HERBATA DATA CENTRE, NAAS - RESPONSE TO REQUEST FOR FURTHER INFORMATION ("RESPONSE TO RFI") FROM KILDARE COUNTY COUNCIL

ADDENDUM TO CHAPTER 1 INTRODUCTION AND NEED FOR EIAR

NI2615
01
June 2025

This Environmental Impact Assessment Report (EIAR) Addendum is provided in response of the Request for Further Information (RFI) from Kildare County Council (dated 4th October 2024) in respect of the proposed Herbata Data Centre Campus (the Project) which is subject of planning application reference 24/60787. The Kildare County Council RFI is provided in Volume II, Appendix 1.1.

DWG NO.				
22217-RKD-ZZ-ZZ-DR-A-1010				
REV.	SUITABILITY	PROJECT NO. 22217		
P09	S3	SCALE 1:1500		
DATE	03/11/2023	DRN	RCD	CHK KOS

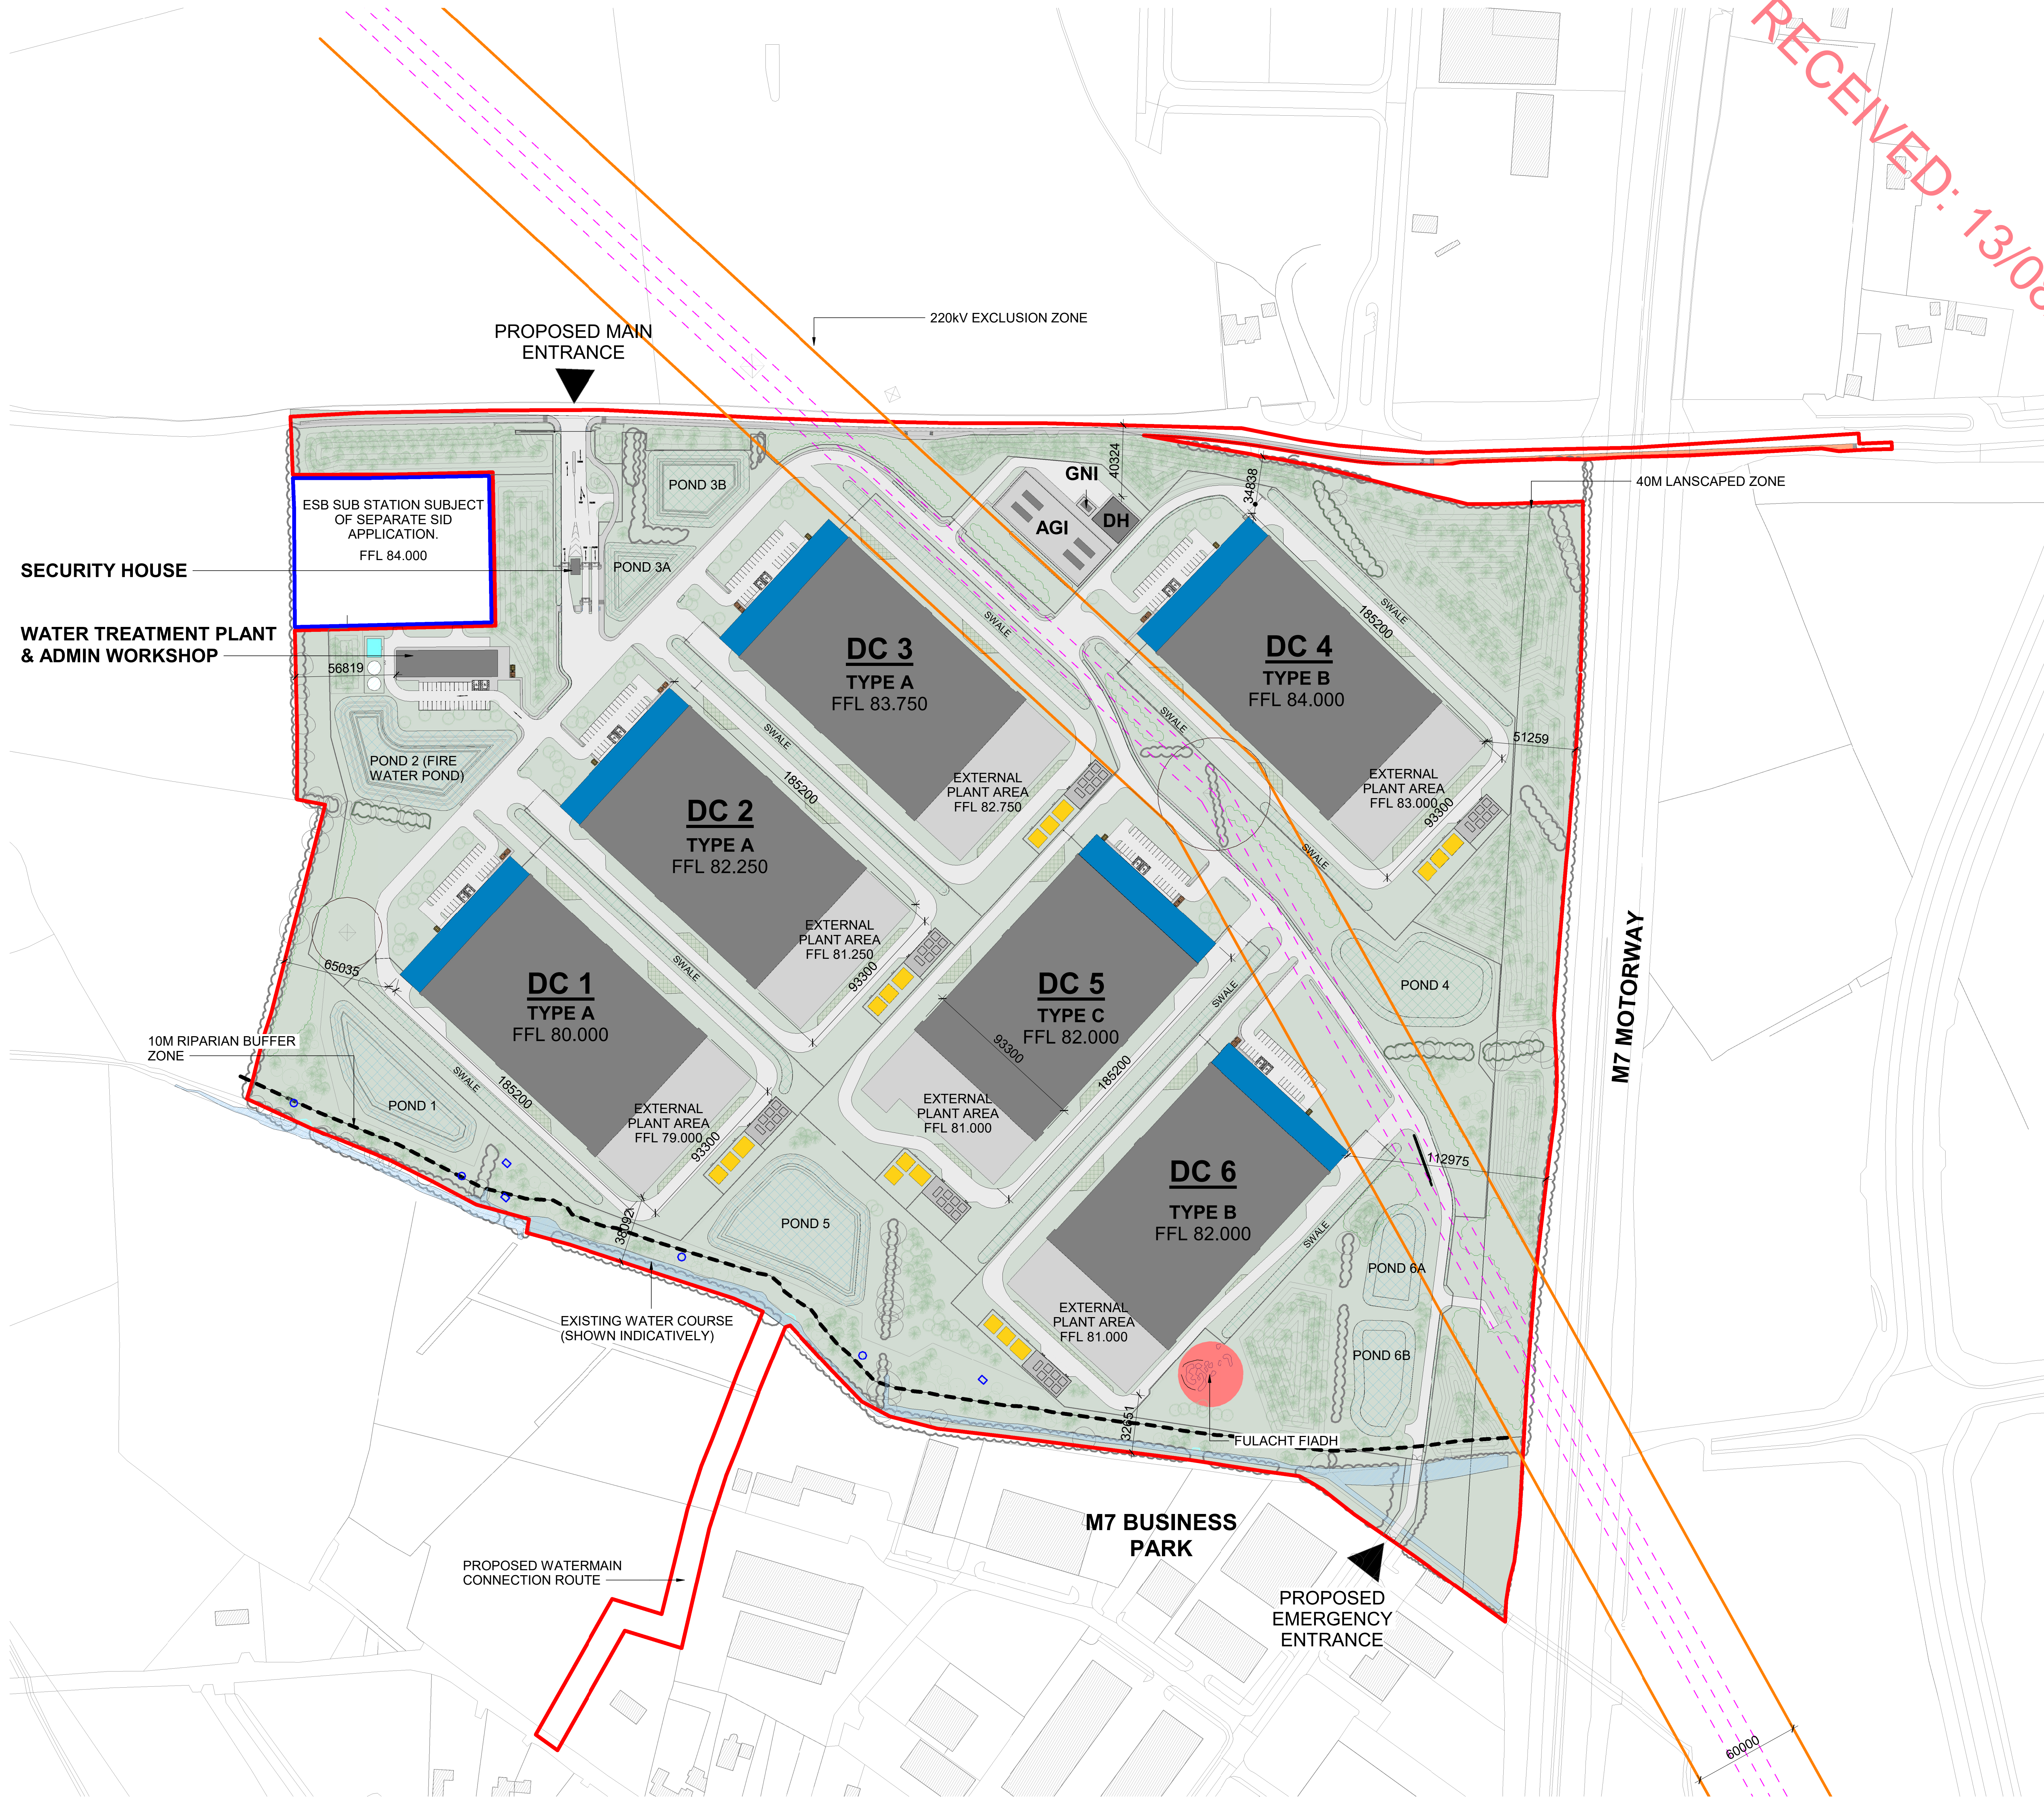
An amended design is proposed for Data Centre 4, primarily in respect of the arrangement of the proposed energy plant area (to the rear of the building) and subsequently, the overall plan of the building.

The amended design of Data Centre 4 is in response to the Kildare County Council RFI (Item 25) having considered the potential archaeological feature identified to the south east corner of the building; further detail and consideration of this is provided in the Addendum to Chapter 10 Cultural Heritage of the EIAR.

In order to accommodate the amended design of Data Centre 4 building, minor amendments to the layout of ancillary elements (such as security fencing, access road, drainage etc) which are within immediate vicinity of the building, are proposed. The component elements of Data Centre 4 (as summarised in Section 1.2 (a) above), the location within the overall site, building height, materials and finishes, remain unchanged.
